Ribble Valley Borough Council
Housing & Development Control

Application no: **3/2022/0966**

Address: **Crow Trees Farm Crow Trees Brow Chatburn BB7 4AA**

The Local Highway Authority have viewed the plans and highway related documents and have the following comments to make:

Proposed Site Layout 1:500

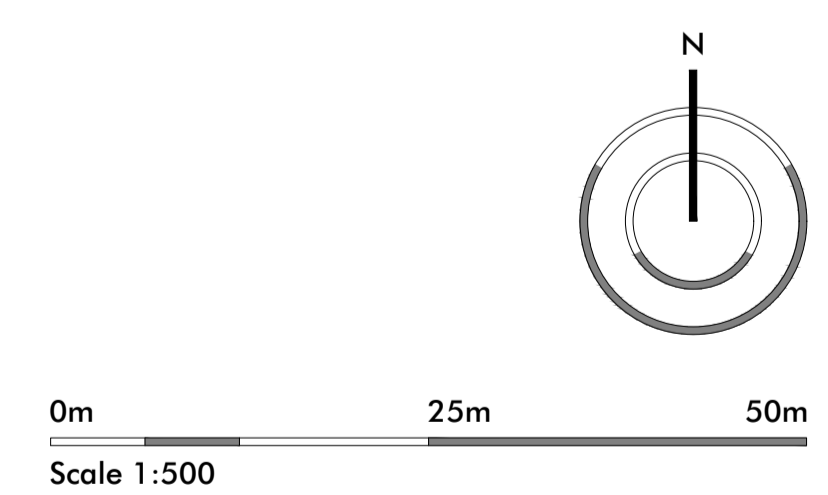
The LHA have reviewed the first access, as shown on LMP drawing number 21/139/P01 Rev A titled "Proposed Site Layout," and are aware that the access will be a minimum of 5.5m wide with a 6m kerb radii and 2m wide footways either side.

In any case, even though the tracking drawing does not comply with the LHAs guidance, the LHA have reviewed the drawing which shows the 9.2m long vehicle using the site access. The LHA have found that the wheels of the tracked vehicle where extremely close to the footway when entering and exiting the site. Therefore, the LHA require given that the tracking drawing does not use the correct dimensions for a refuse vehicle that the access and kerb radii is widened.

However, while the splay to the south of the access complies with the LHAs guidance, the splay to the north doesn't with there a shortfall of 1m. Despite the shortfall, the LHA will accept the shortfall in visibility with it being minimal.

The LHA have reviewed LMP drawing number 21/139/P01 Rev A titled "Proposed Site Layout," and are aware that the internal carriageway will be 5.5m wide. However, to ensure that the width of the internal carriageway is suitable a swept path analysis of a refuse vehicle which measures 11m in length is required.

The LHA also require the speed hump traffic strips to be removed and replaced by road humps which comply with the LHAs specification.

Furthermore, the LHA are aware that 2m wide footways are provided either side of the carriageway at the site access and from where Plot 26 is located, internally. In between these points, the footway to the left of the access ends approximately 8.8m into the site.

For the LHA to adopt an internal layout which does not have 2m wide footways either side of the carriageway, the LHA require a 0.5m hard paved strip to be provided where there is no footway. This should then be widened to 1m where the proposed streetlights will be located. Therefore, the LHA require this amendment to be made on a revised plan.

The LHA have determined by reviewing the drawing that the turning head is inadequate even for this type of vehicle. This is because the 9.2m long vehicle will overlap the footway when undertaking the turning movement to enable the vehicle to exit the site in a forward gear, which is unacceptable. The wheels of the vehicle are also extremely close to the footway. Therefore, the LHA require the turning head to be amended and be more formalised.

The LHA require the boundary treatments for the private access track serving Plots 1-4, Plots 14-18 and Plots 32-39 and the private driveway for Plot 5 and Plot 19, as shown on LMP drawing number 21/139/P01 Rev A titled "Proposed Site Layout," to be no higher than 1m when located within the access's visibility splays.

The LHA are aware that Plots 1 to 4; Plots 14-18; Plots 27-31 and 32-39 will all be accessed via a shared access track. The LHA require visibility splays of 2.4m x 25m are provided in both directions at each shared access to ensure that they can provide the minimum visibility for a 20mph road and that nothing above 1m will obstruct visibility.

The LHA also require bin collection points to be provided at each shared access to serve the respective plots. The LHA advise that these should be located out of the junction's visibility splays and should not be located on the footway.
